Suffolk County Council (20031377)

Issue-Specific Hearing 4 (ISH4) Post-hearing Submission

Sunnica Energy Farm (EN010106)

3 March 2023

SUNNICA EAST SITE B,
SITE ACCESS D & H (SE-D) & (SE-H)
NEWMARKET ROAD (SHEET 2 OF 2)

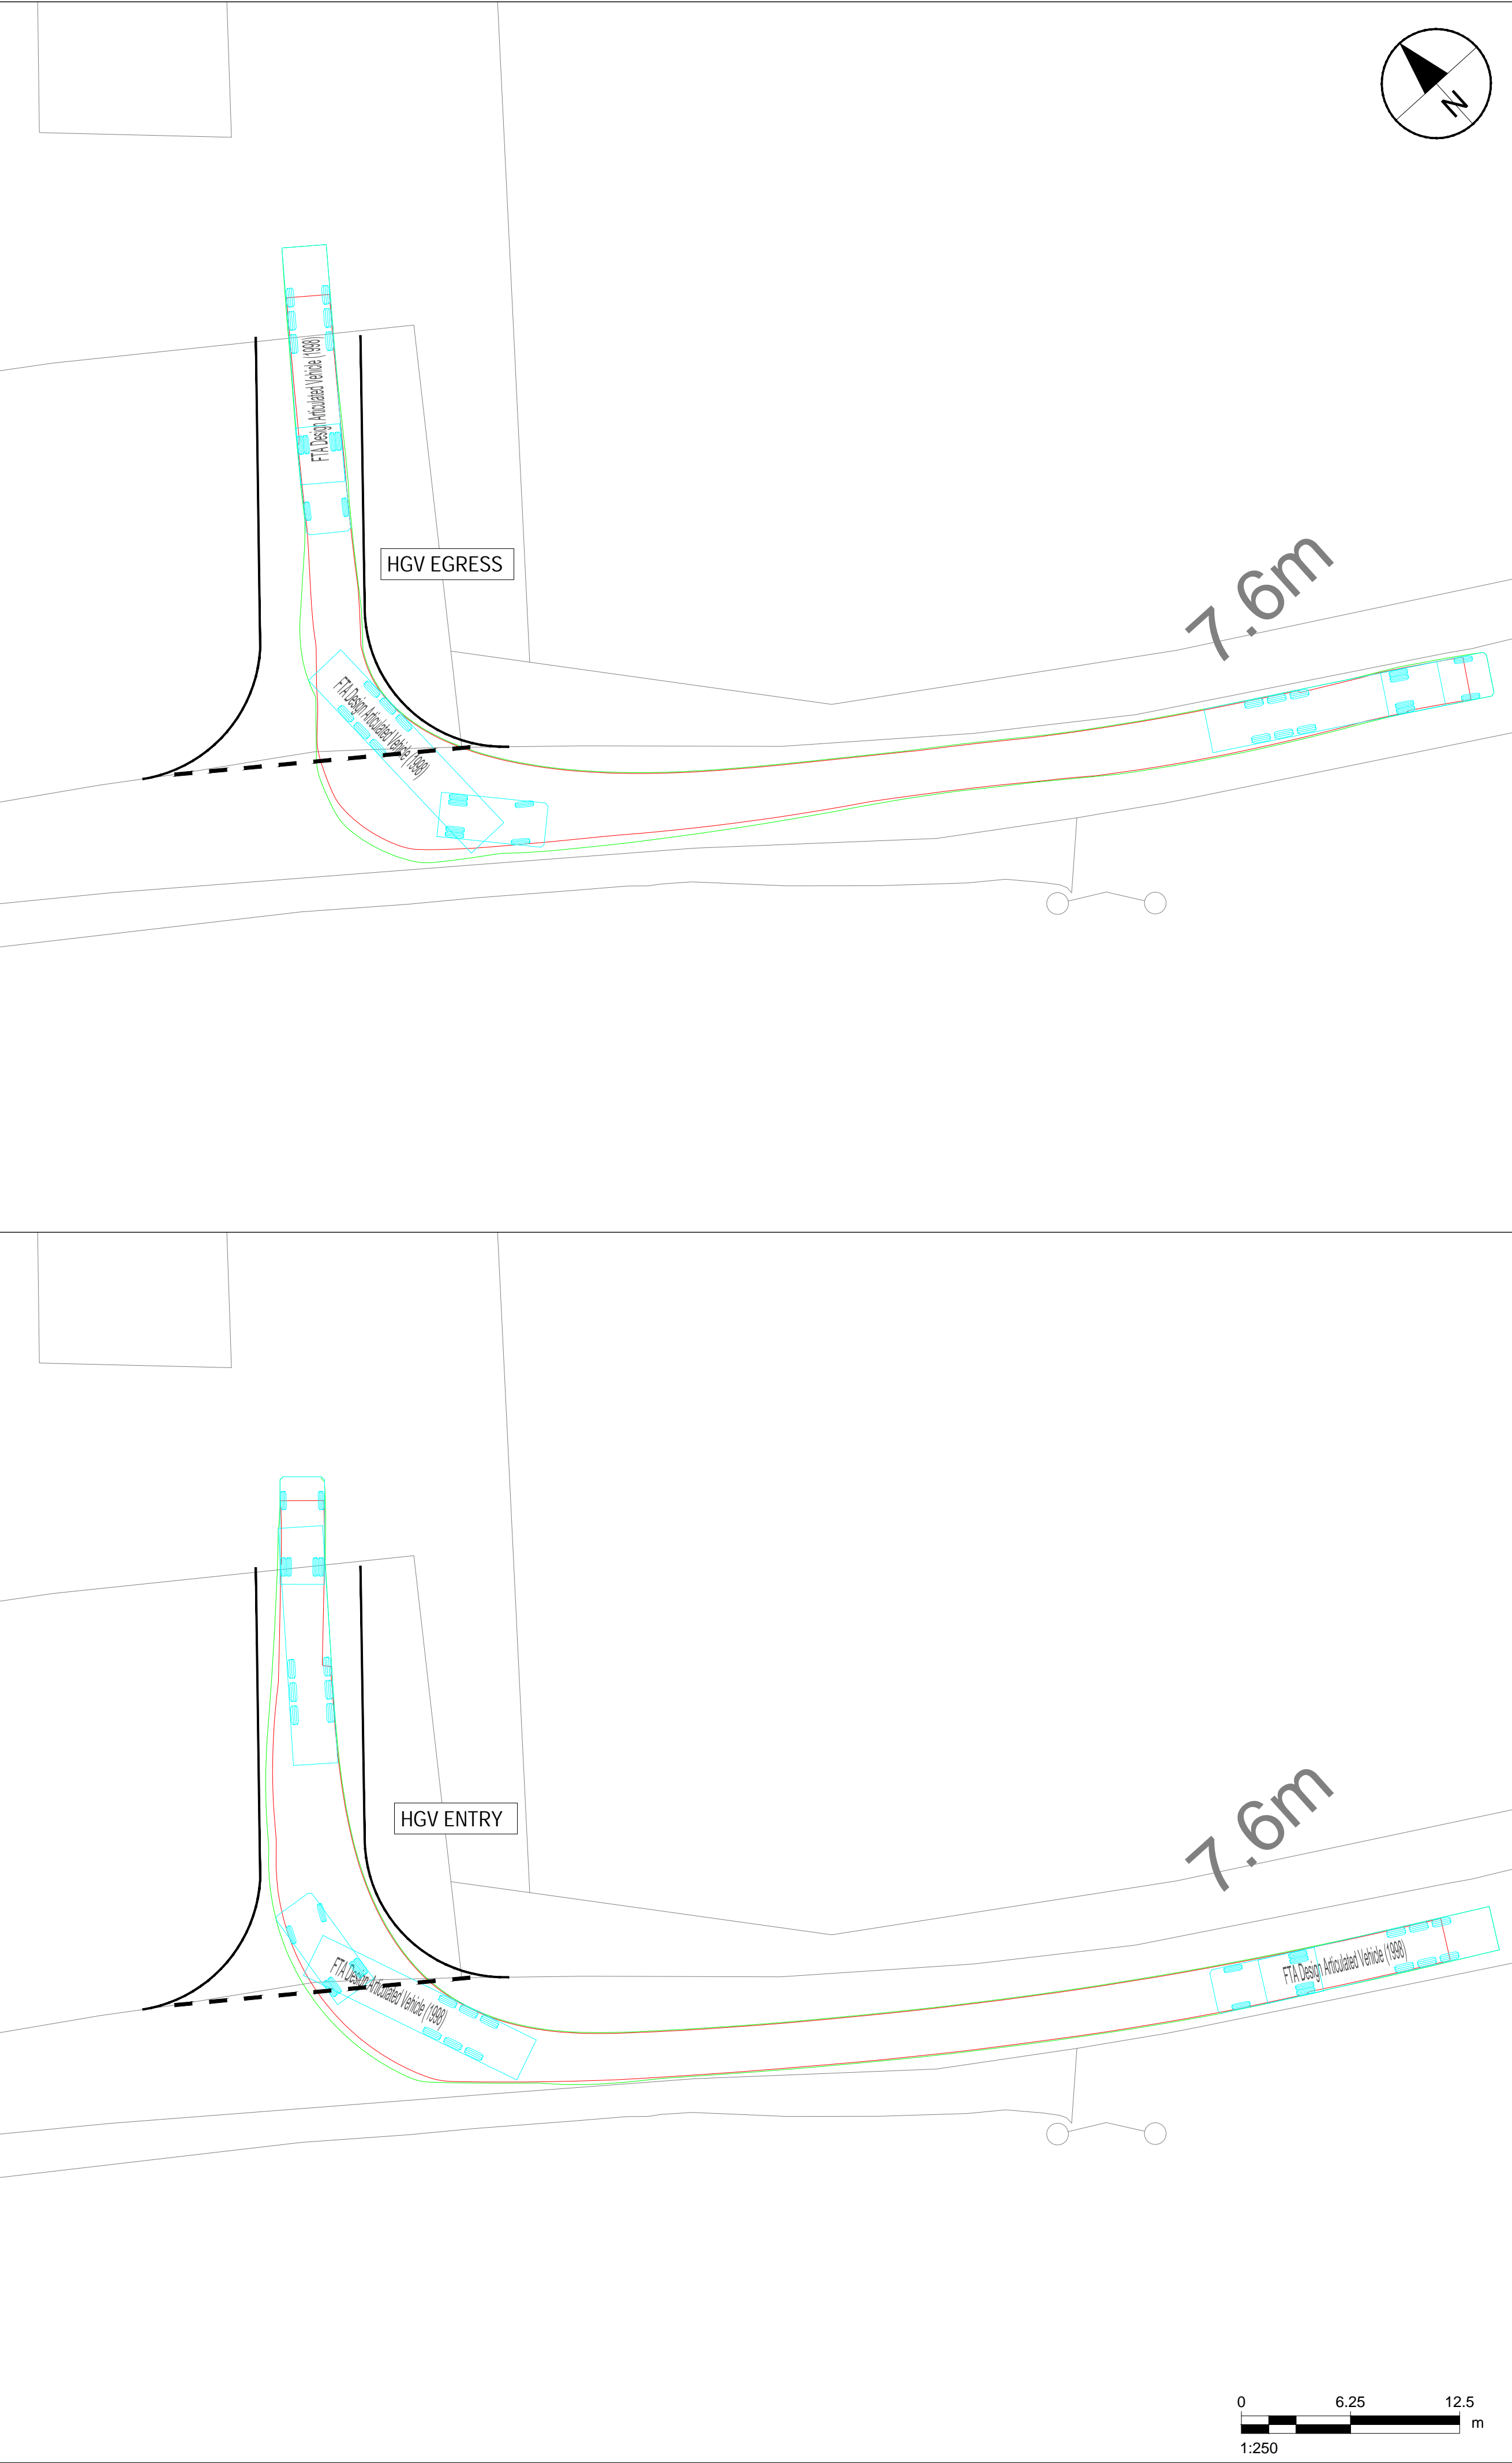
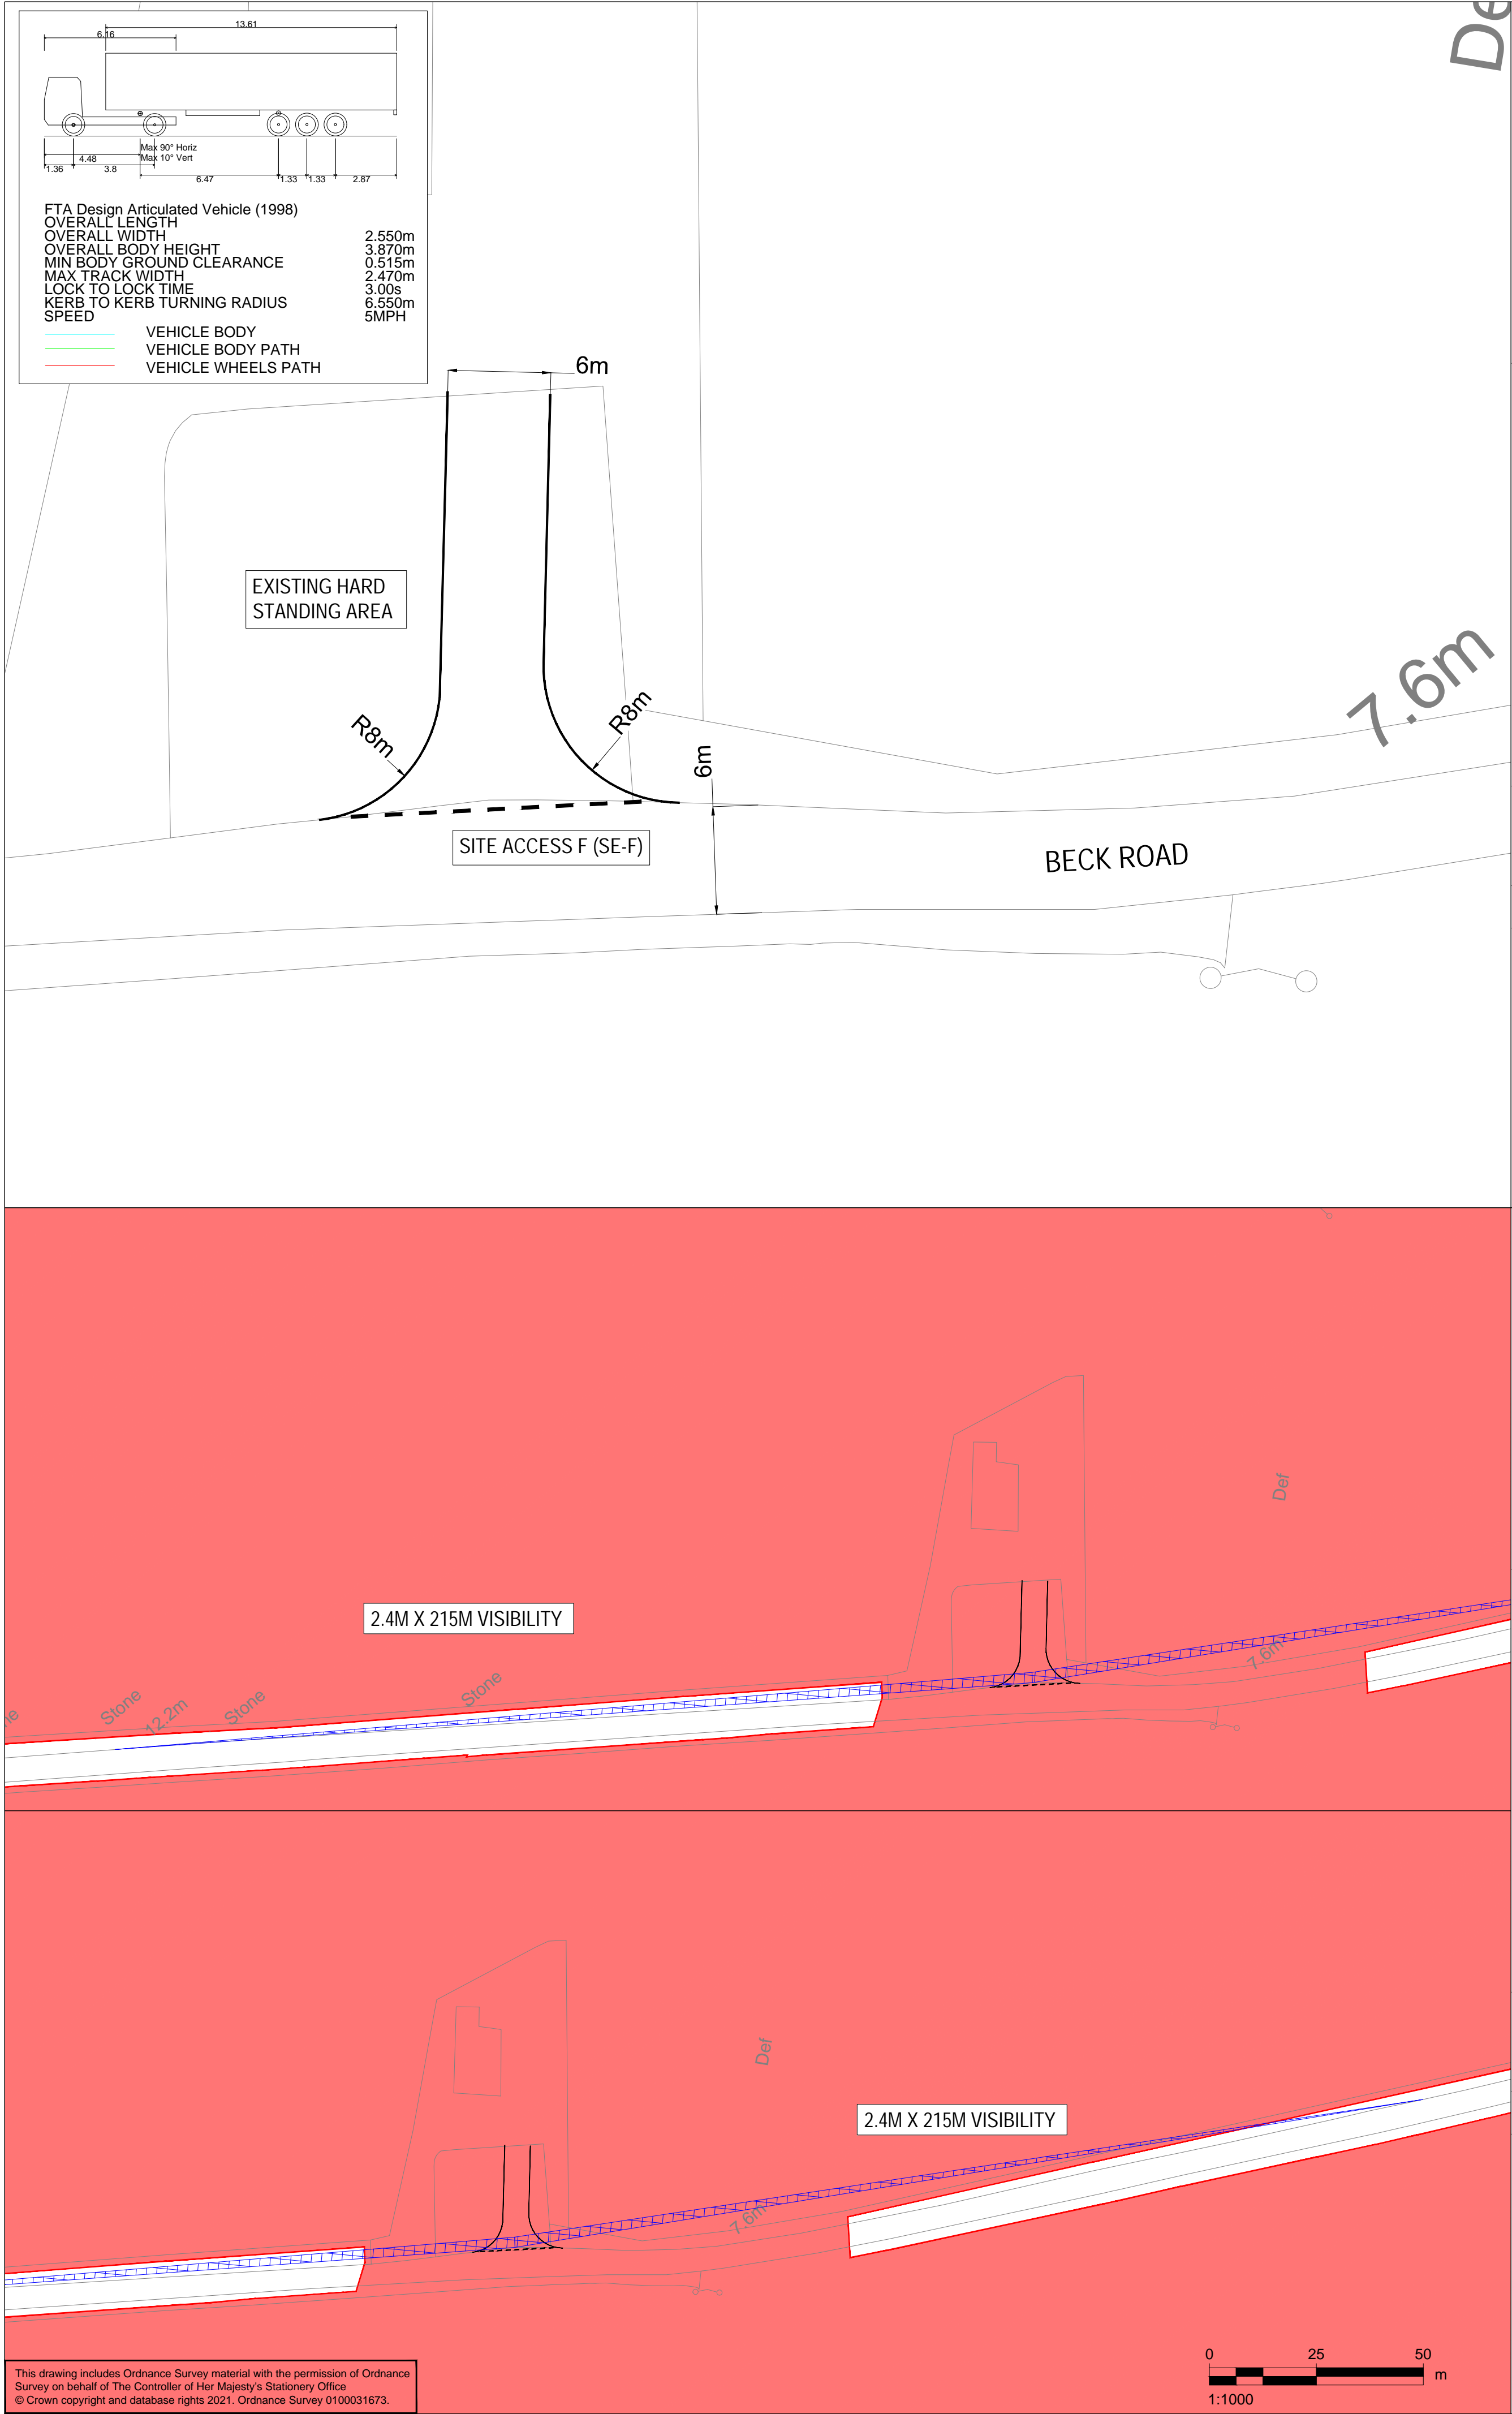
No visibility details provided for Access D during the operational phase (no traffic management). Vegetation removal for Access H under-estimates the depth of woodland / hedges.
